Subject: RE: Silo at Highdown. FG/135/19/PL

The decision notice states that the Office has to be built out in accordance with drawing WLD/0063/19/02 (Condition 2). Before development takes place above damp proof course, the applicant has to provide details of materials for external walls and roof (Condition 3). Whilst this is fine and self explanatory, one detail of the building the architect removed for the second committee meeting was the weathervane, as this was deemed not

SCALE AT A1: As indicated	DATE: 14/05/19	DRAWN: AP	CHECKED:
PROJECT NO: SILO	DRAWING NO: WLD/0063/19/02	REVISION:	C

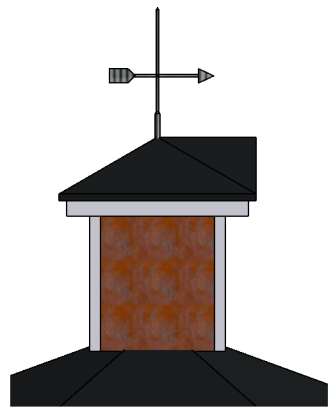
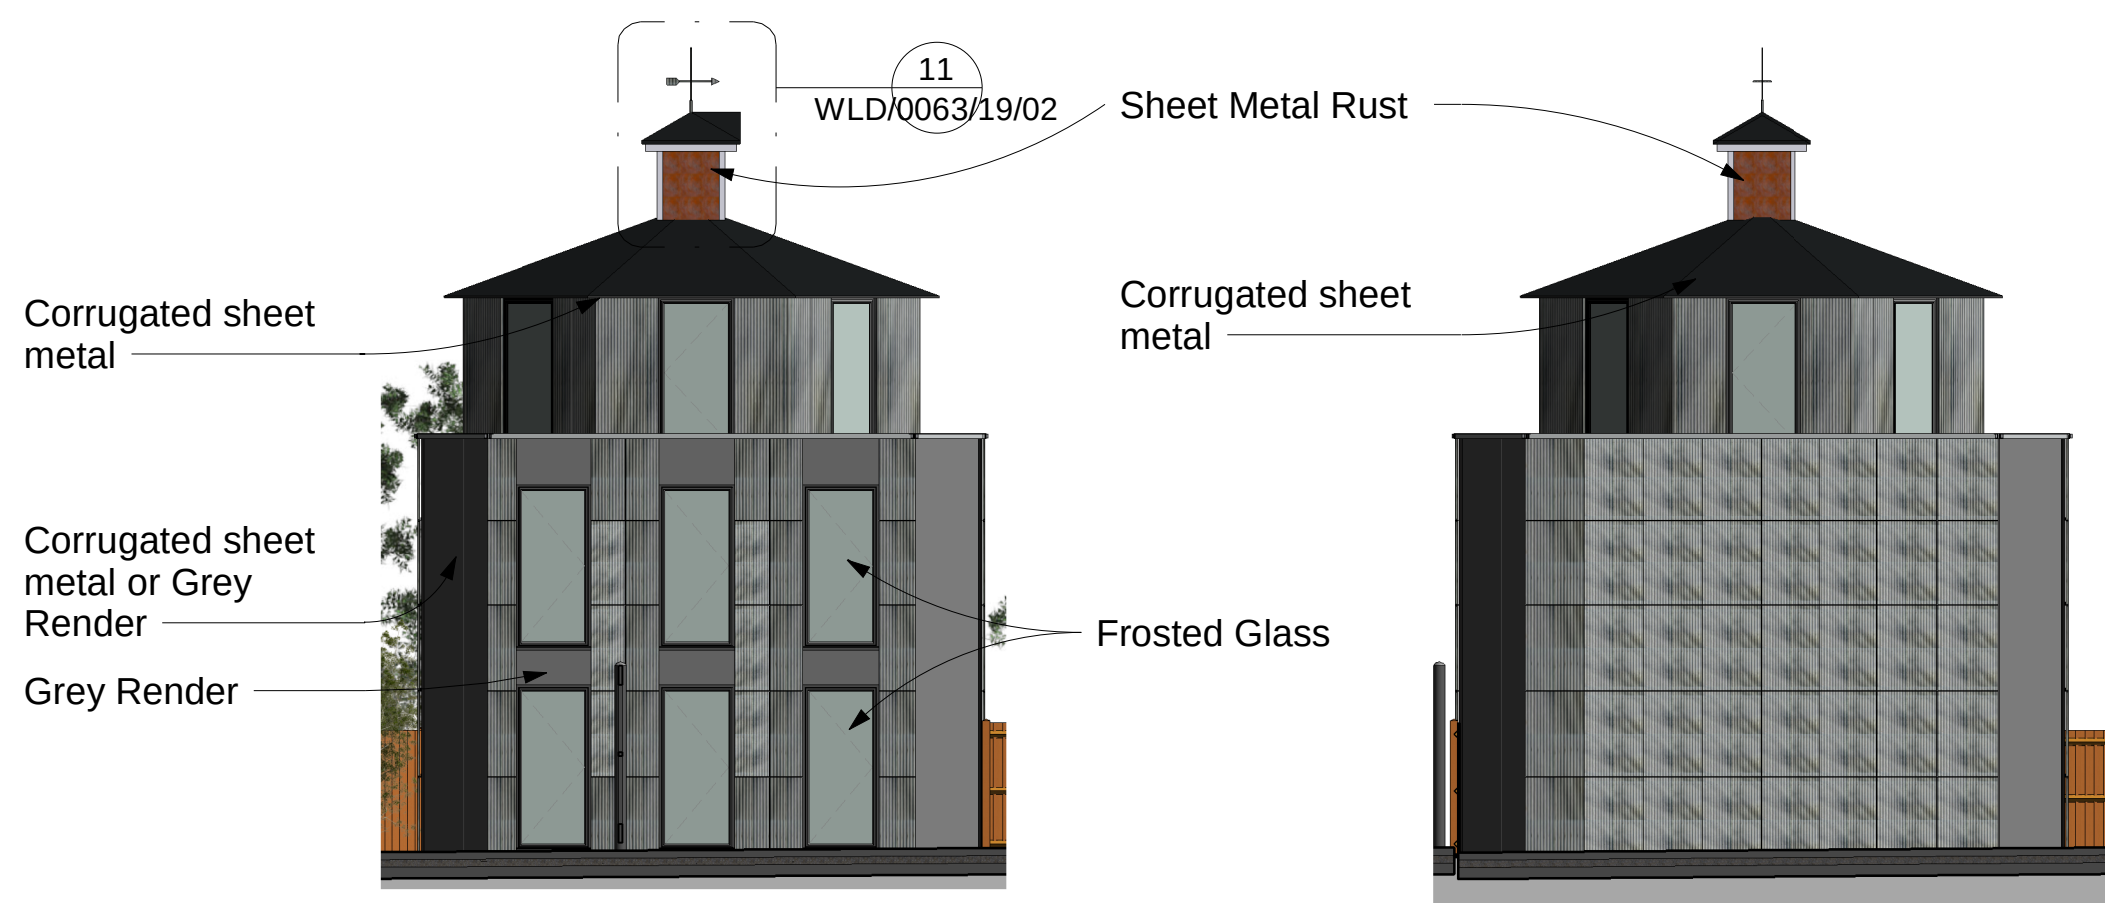
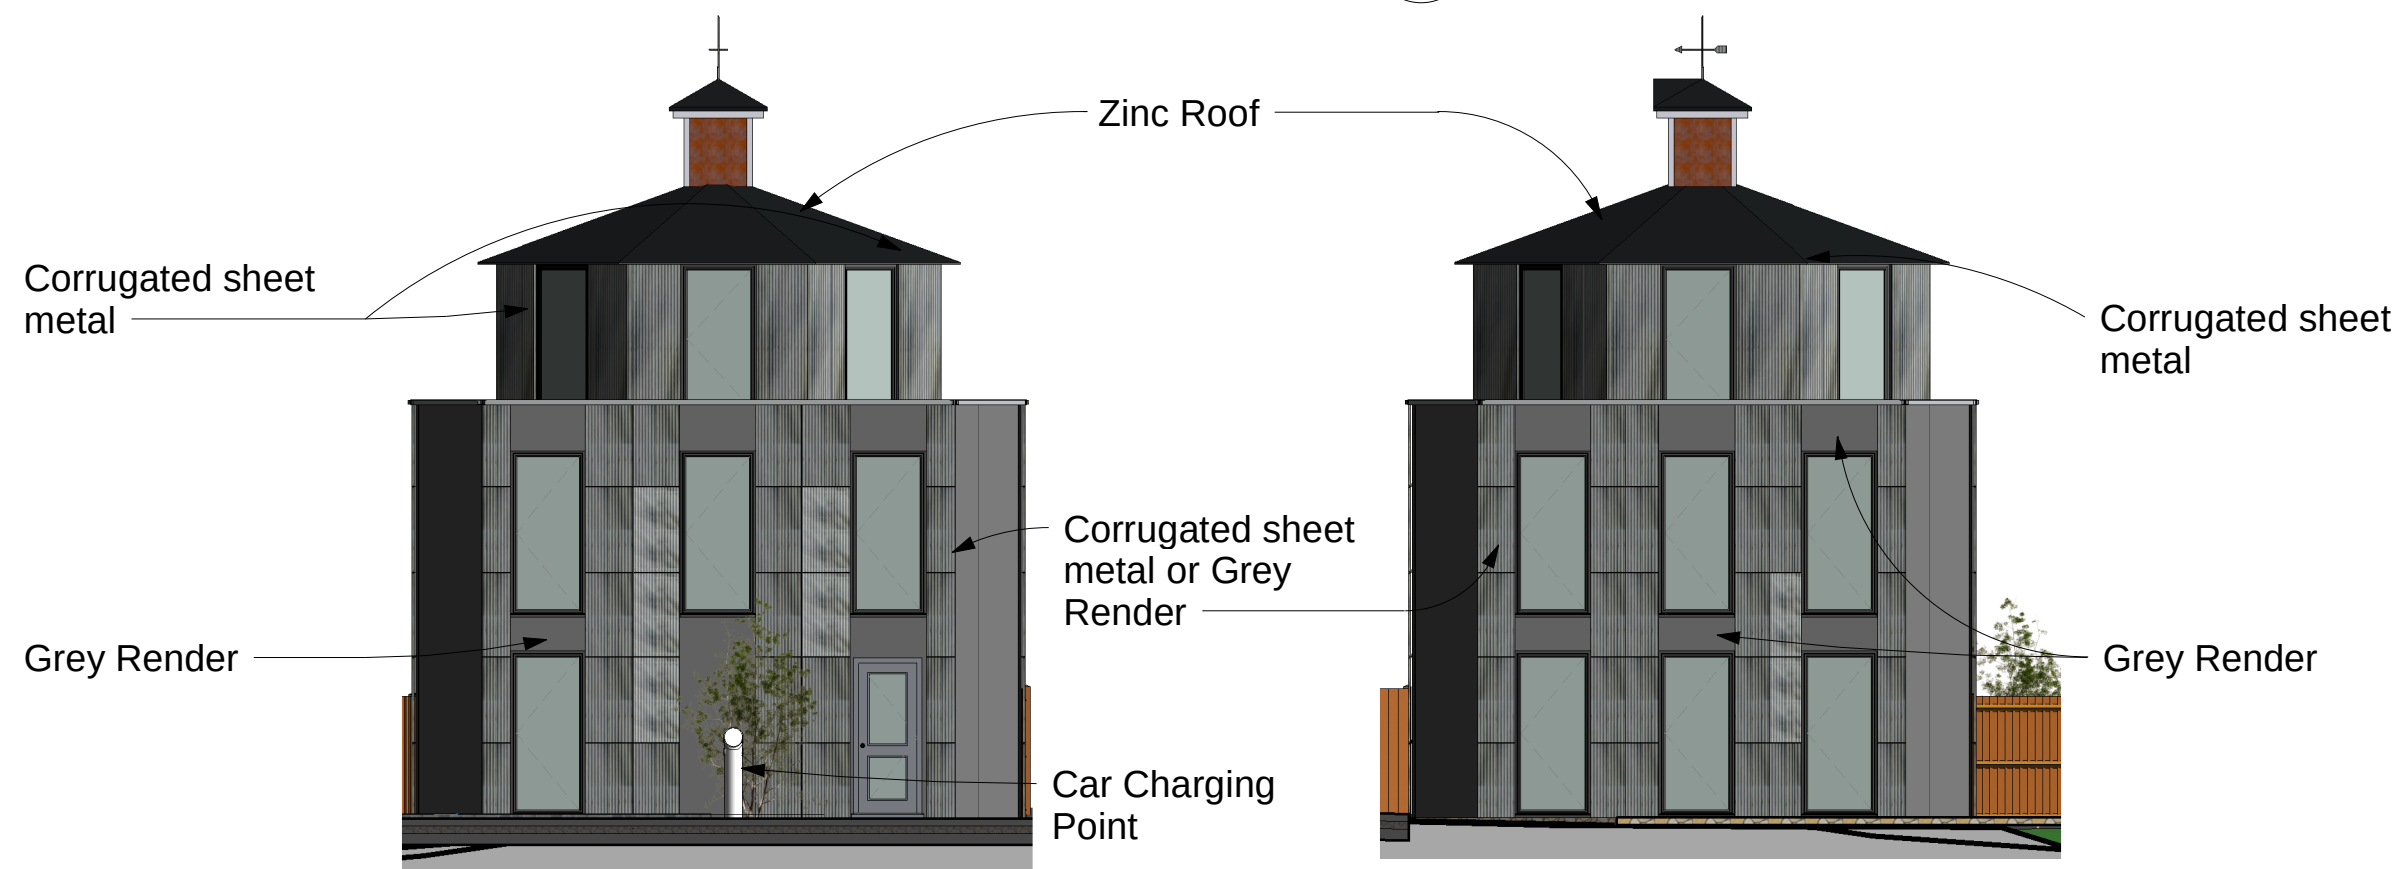
appropriate in the first committee meeting and members argued against it. However, if we are developing the office to the above drawing plans and elevation, it will include the unwanted weathervane.

Please advise whether this condition therefore needs to be amended and whether the architect needs to amend drawing 19/02.

I recall the situation you are speaking about, I believe this has occurred because there were no substitute plans as part of the renewed scheme.

When you apply to discharge the condition relating to the approved materials, if you provide a plan (which does not include the weathervane) Arun District Council are able to consider this to be an approved plan, which therefore supersedes the previous.
